From: Chantelle Bashford <Chantelle.Bashford@arun.gov.uk>
Sent: 24 September 2020 14:41
To: Planning.Responses <Planning.Responses@arun.gov.uk>
Subject: RE: Planning Consultation on: BR/131/20/PL

Please see comments from Private Sector Housing below.

Application No: BR/131/20/PL
Registered: 14th July 2020
Site Address: Land between 2b and 4 London Road Bognor Regis NEAR PO2
Grid Reference: 493619 99101
Description of Works: Erection of a commercial unit at ground floor level with residential development of 3 no. bedroom flats above. This application is in CIL Zone 4 (Zero Rated) for flats & shop (Zero Rated).

JJR DESIGNS Limited

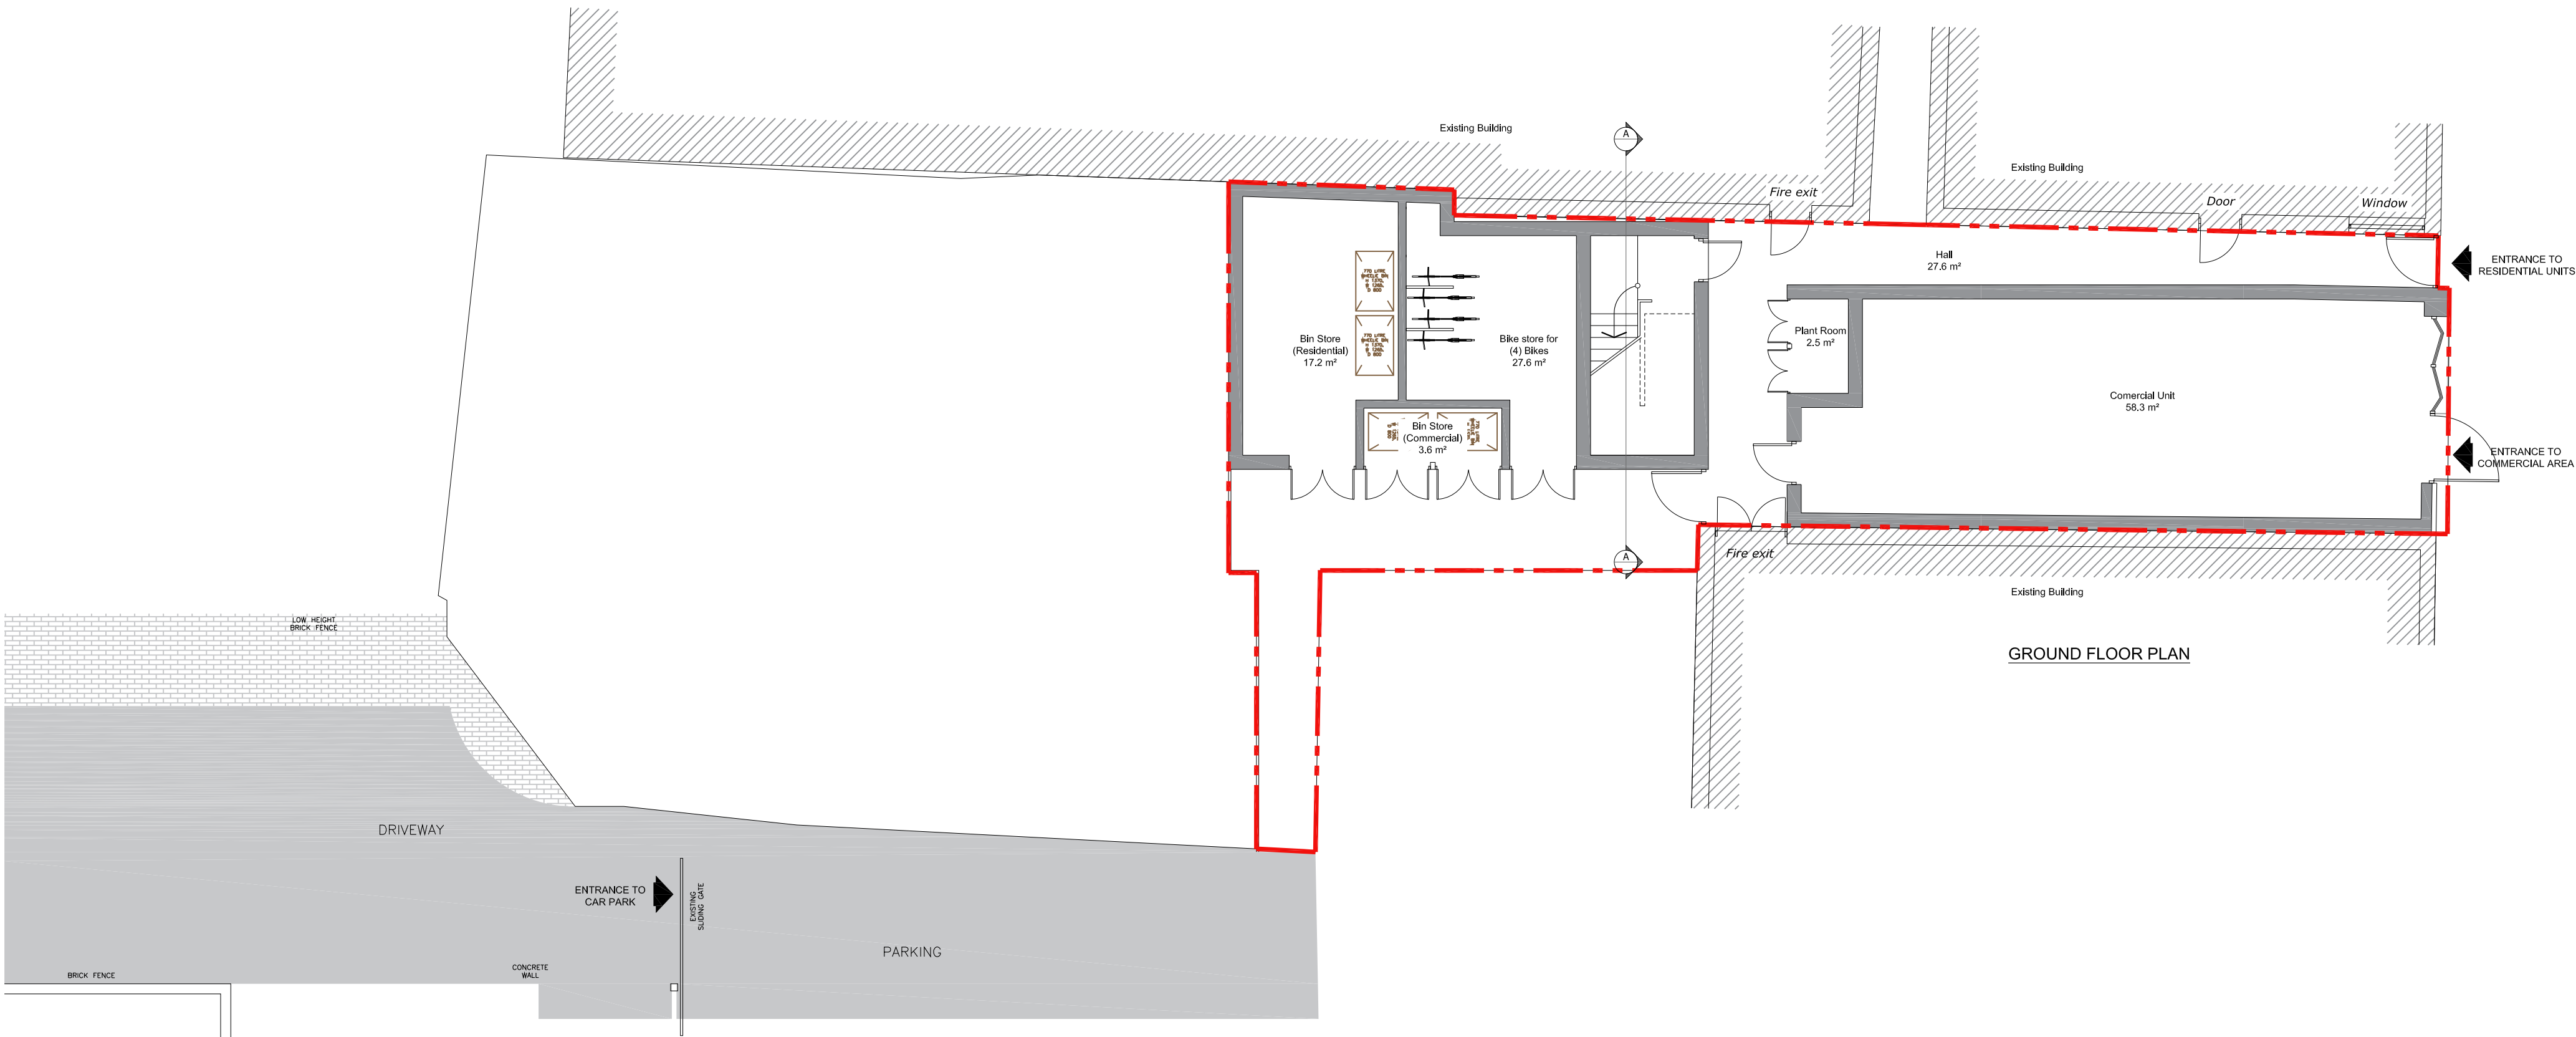
- Appropriate fire precaution facilities and equipment must be provided of such type, number and location as are considered necessary. Guidance on fire safety is contained in the LACORS guidance document – “Housing – Fire Safety, Guidance on fire safety precautions for certain types of existing housing”
- There should be adequate fire separation (usually 60 minutes) between the commercial unit on the ground floor and the residential flats above
- The internal escape route should provide 30 minutes fire resistance, including the provision of 30-minute fire resisting and self-closing fire doors (FD30S) to each flat entrance. If the plant room on the ground floor hallway is housing any electrics/electrical items, FD30S doors will also be required there
- A mixed Grade A, LD2 and Grade D1, LD3 fire system should be maintained and installed

- Interlinked detection throughout the escape route
- Interlinked detection in the commercial unit
- Interlinked detection in the plant room (if any electrics are present)
- Interlinked heat detection to each flat

- Non-interlinked mains-wired smoke alarms with integral tamper-proof battery back-up to each flat

N.B. A Fire Risk Assessment may also recommend interlinked detection is installed within both bin stores

- Fire blankets should be provided to all kitchen areas
- Emergency lighting is likely to be required to the escape route due to borrowed light possibly being limited

- Kitchens should have adequate mechanical ventilation
- Mechanical extraction should be provided to all bathrooms/shower rooms/en suites

- Must meet the requirements of the Housing Act 2004 and be free of Category 1 and significant Category 2 Hazards
- Units 1 & 2 have the potential to operate as a House/Flat in Multiple Occupation (HMO), depending how they are occupied. If either flat becomes an HMO, it must;
- Meet the requirements of the Arun District Council Houses in Multiple Occupation Standards (2020)
- Meet the requirements of The Management of Houses in Multiple Occupation (England) Regulations 2006
- Meet the requirements of any other associated Housing and/or Houses in Multiple Occupation legislation or regulations if applicable to the property/site

- It is noted there are two fire exits and a door leading from three surrounding buildings into the communal hallway on the ground floor, presumably providing an escape route from these neighbouring properties. Having an escape route lead into another building is not ideal and poses a number of potential issues such as the exits being blocked by tenants' belongings. It would be advisable to communicate with the owner(s) of these three buildings to discuss the escape routes and perhaps even to get a legal agreement put in place. Additionally, the Fire Risk Assessments for the three surrounding buildings may not deem the escape routes suitable if they have to pass through a neighbouring building.

Drawing Title:
PROPOSED ELEVATIONS

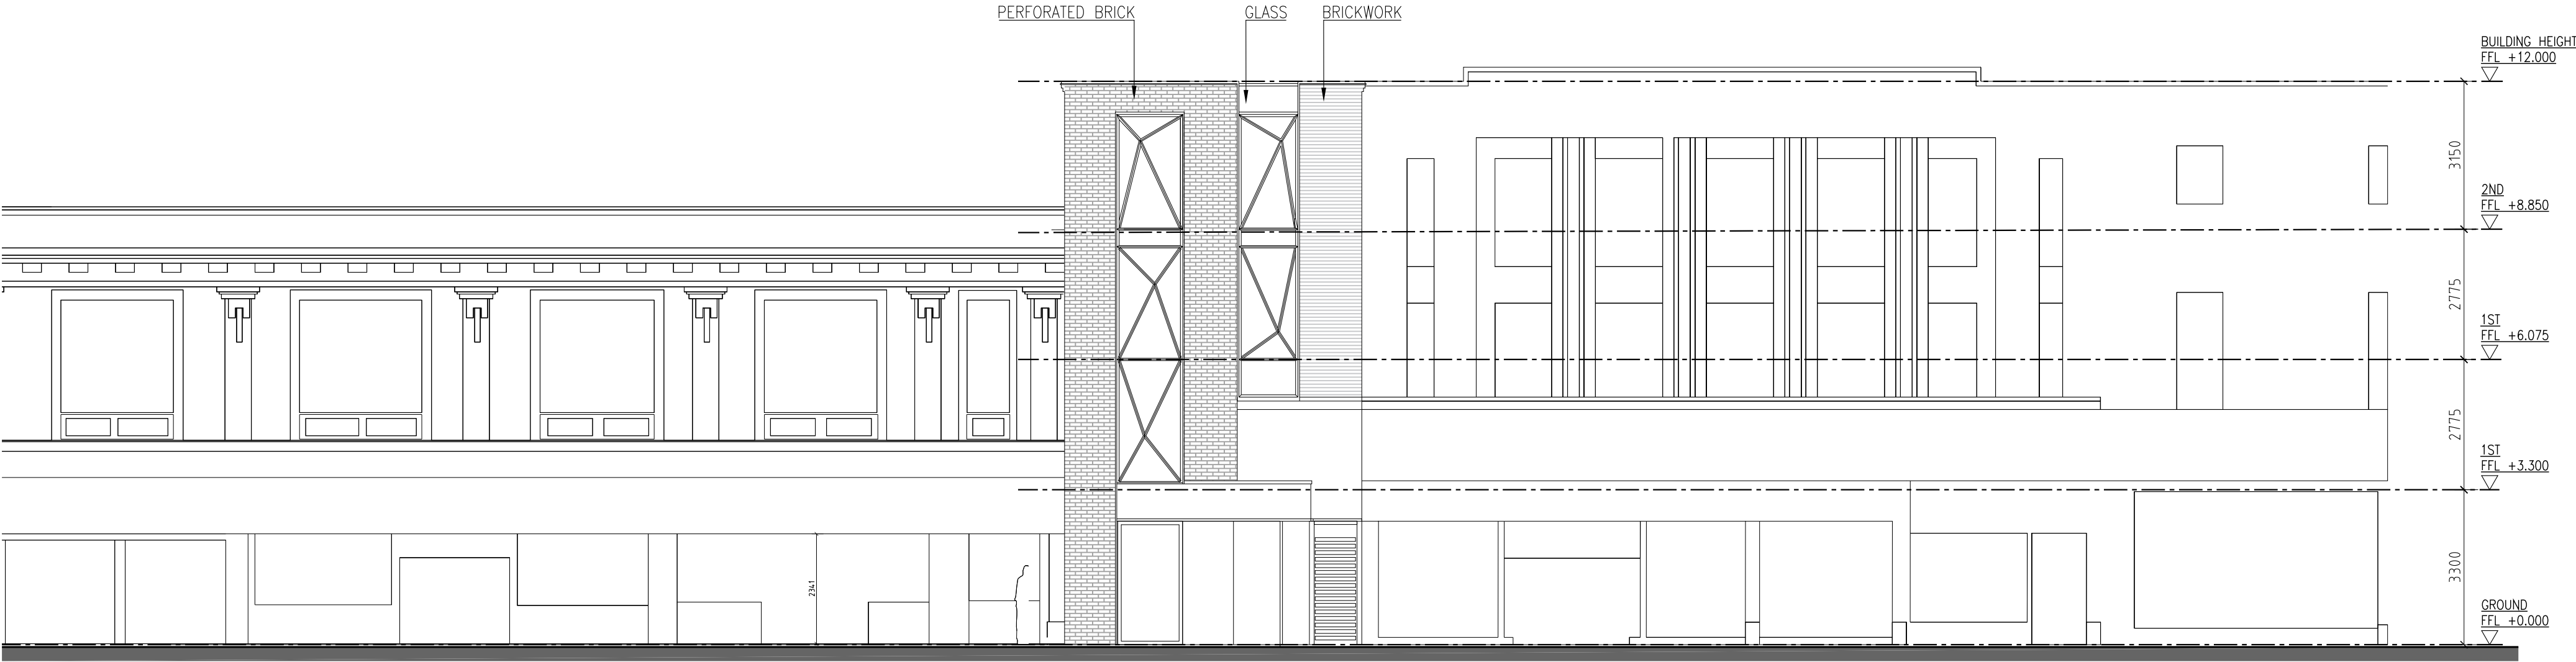
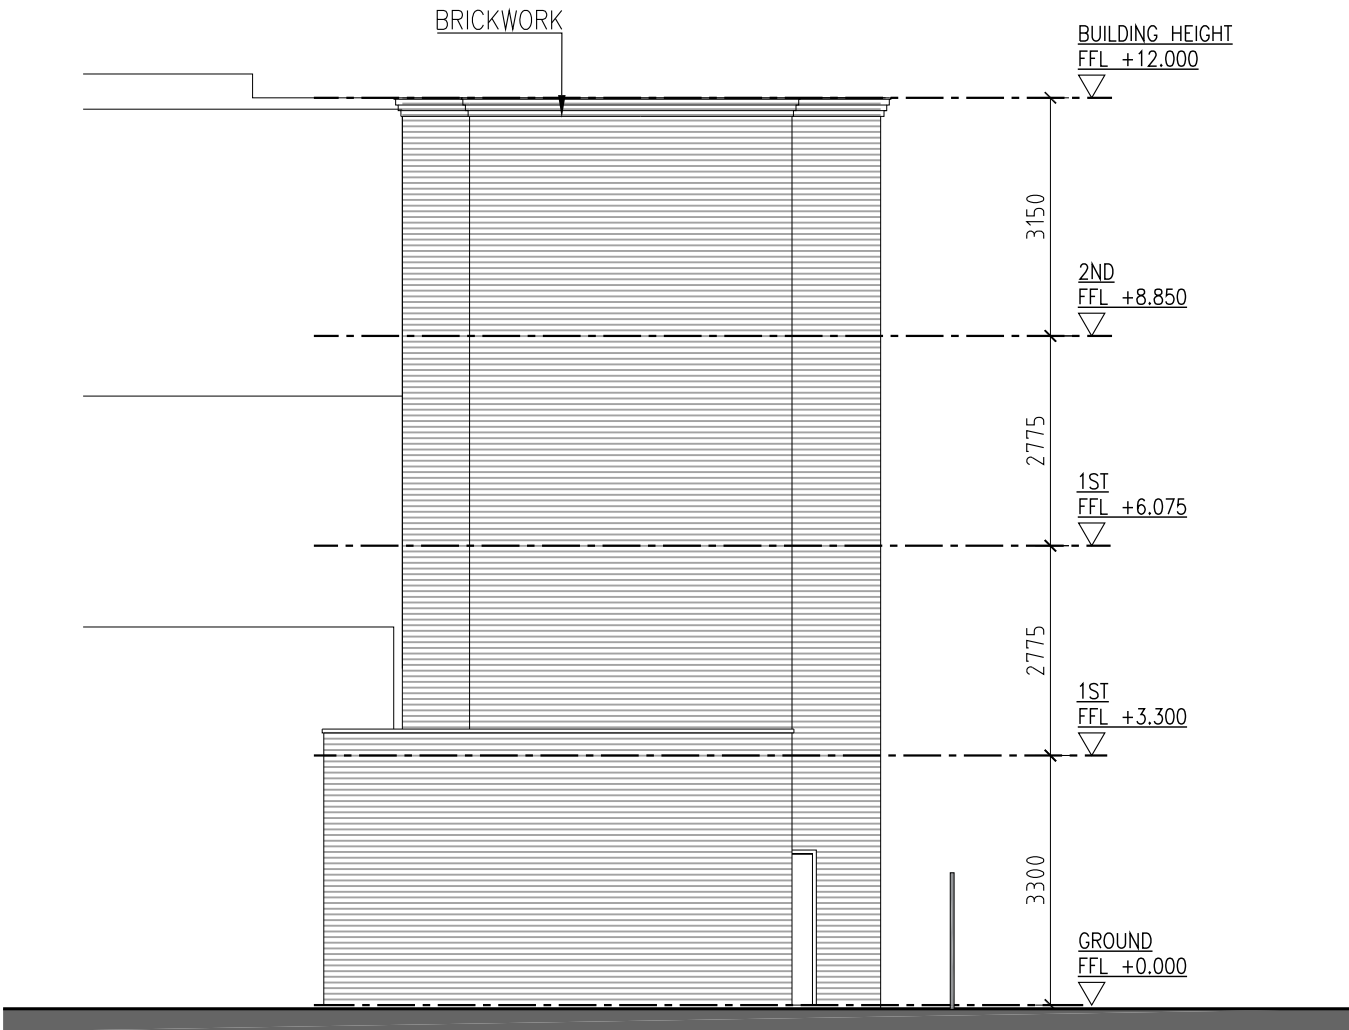
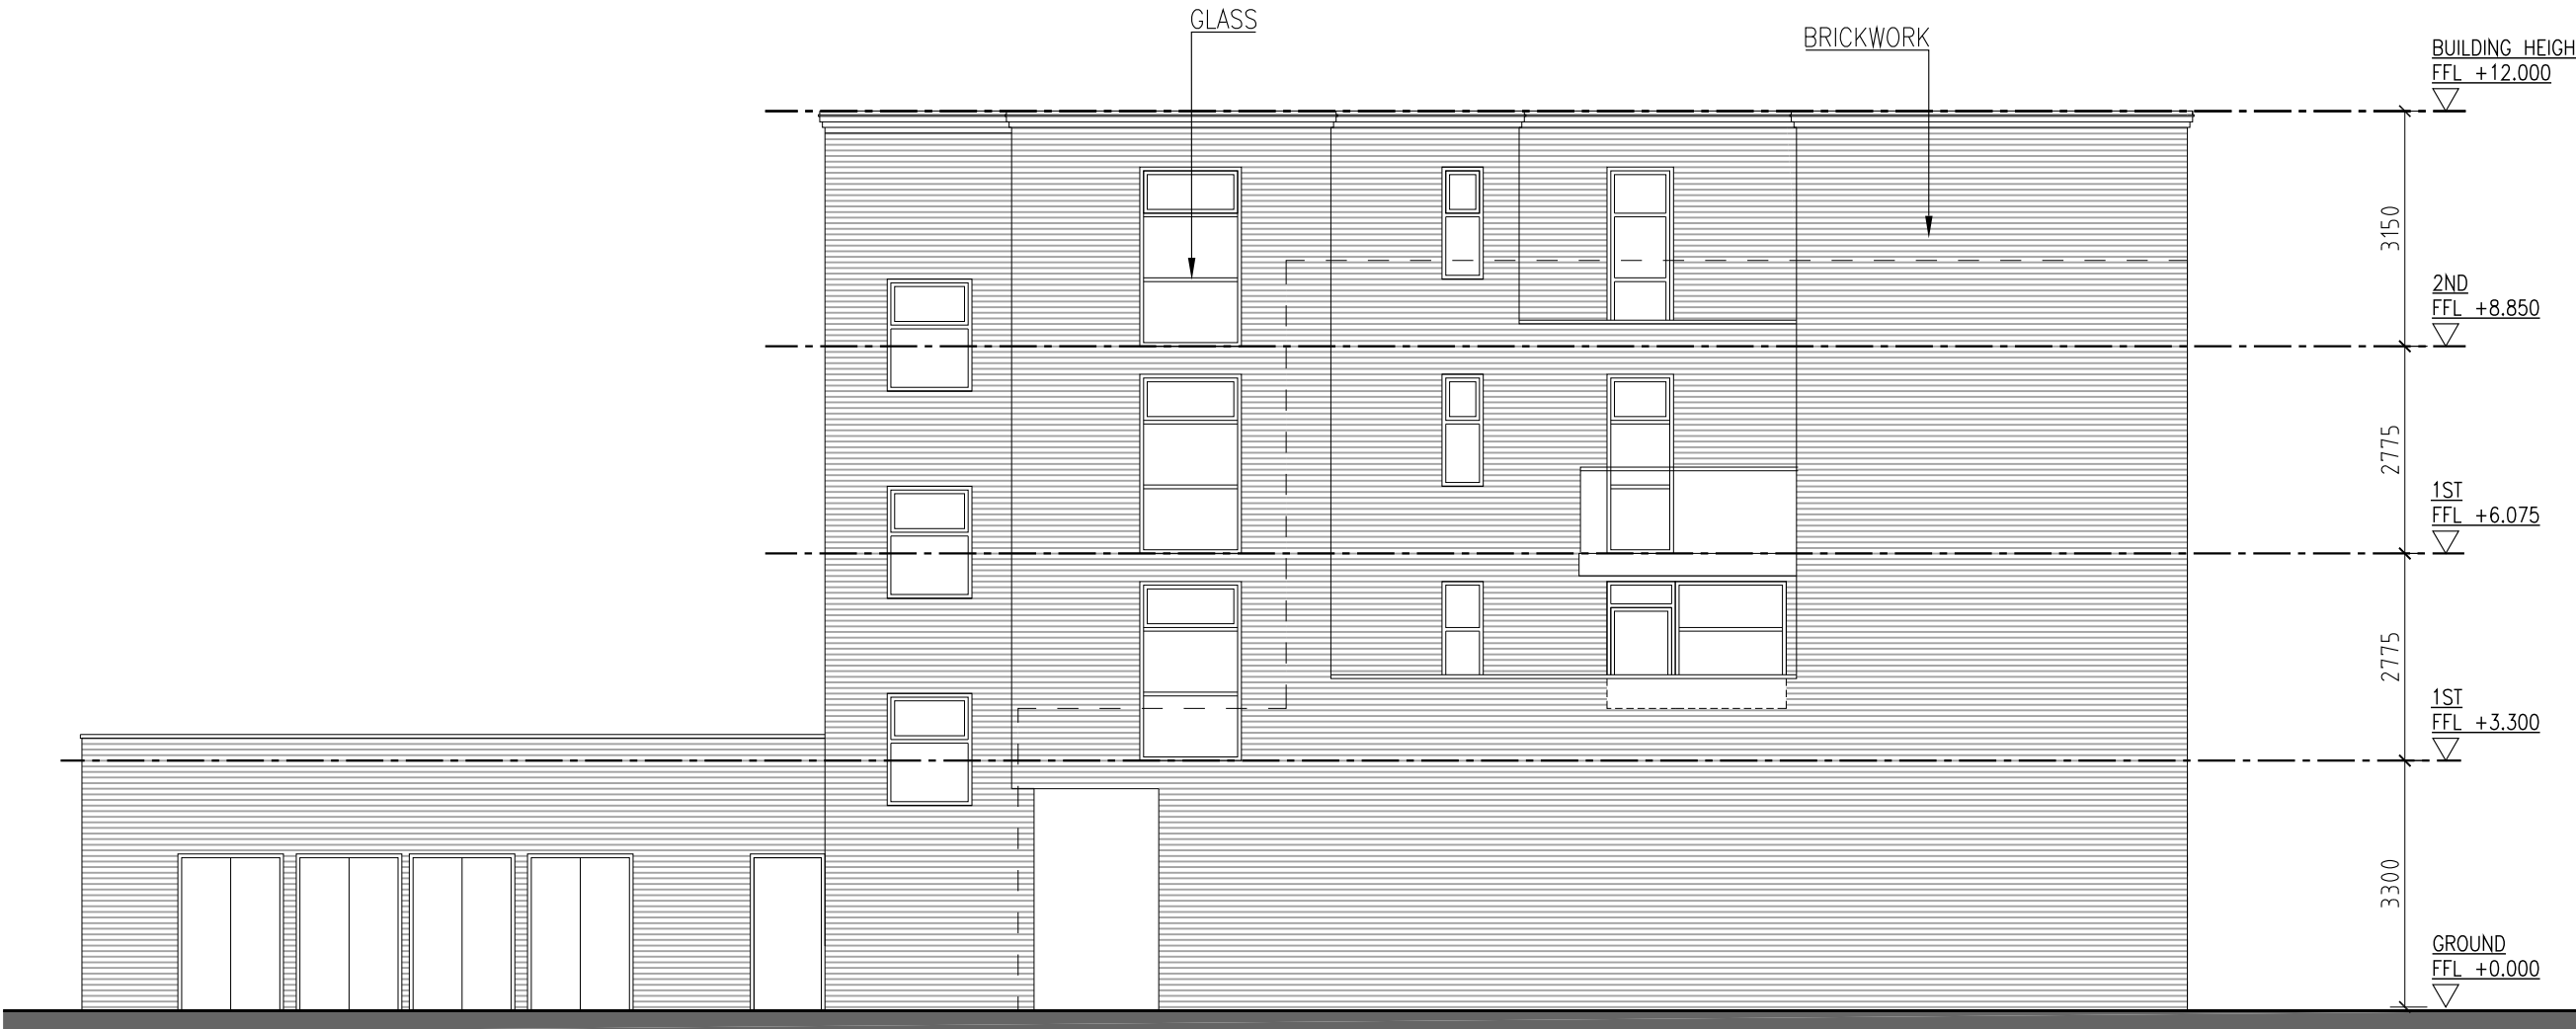
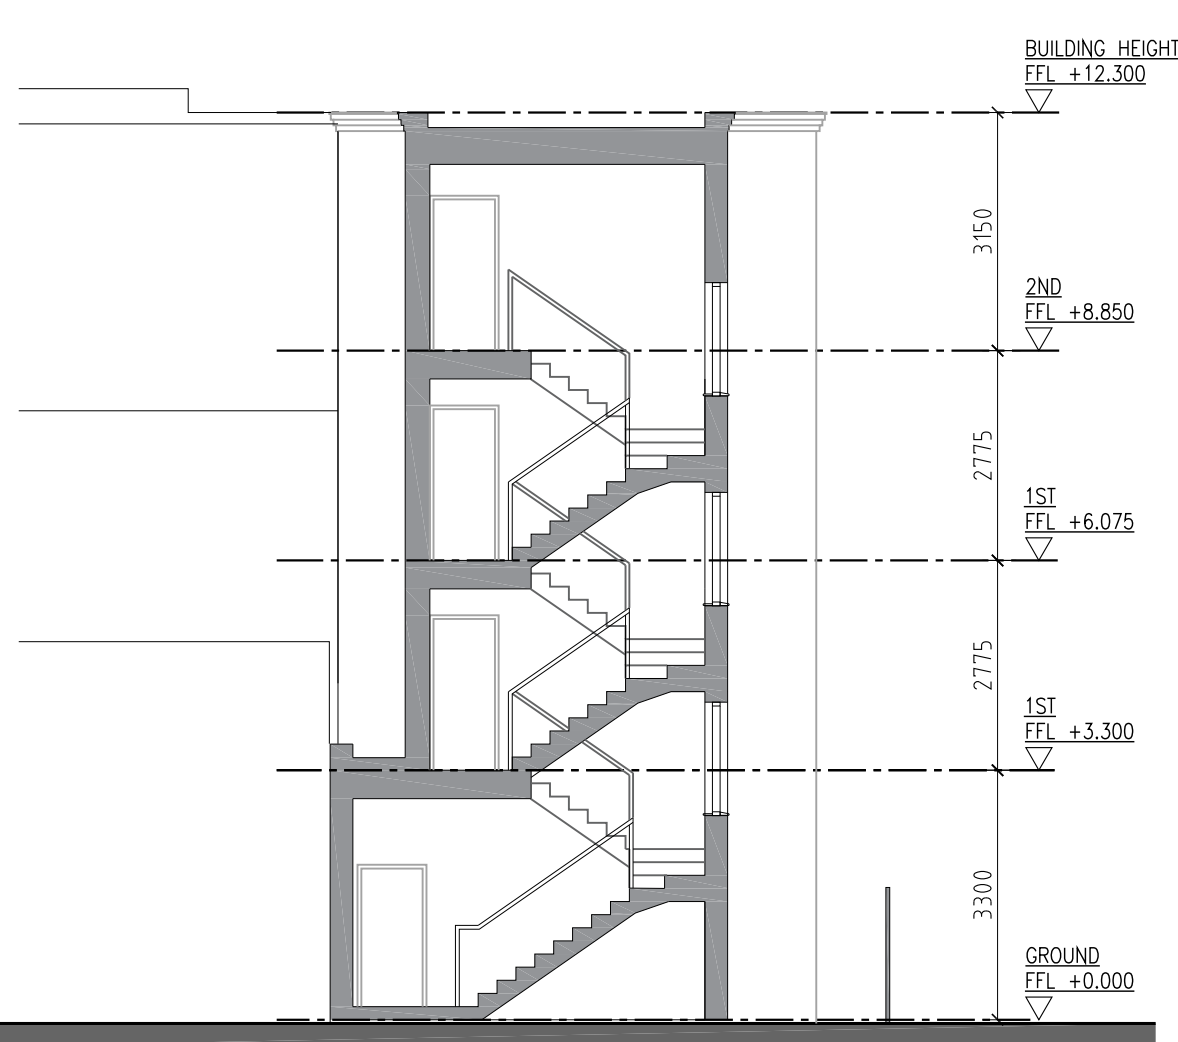
- Each terrace/balcony must provide a guarding height of 1100mm minimum, extending up from the terrace/balcony floor
- The openings within the guarding should not allow a sphere with a 100mm diameter to pass through
- The guarding should not be constructed so as to facilitate climbing by children
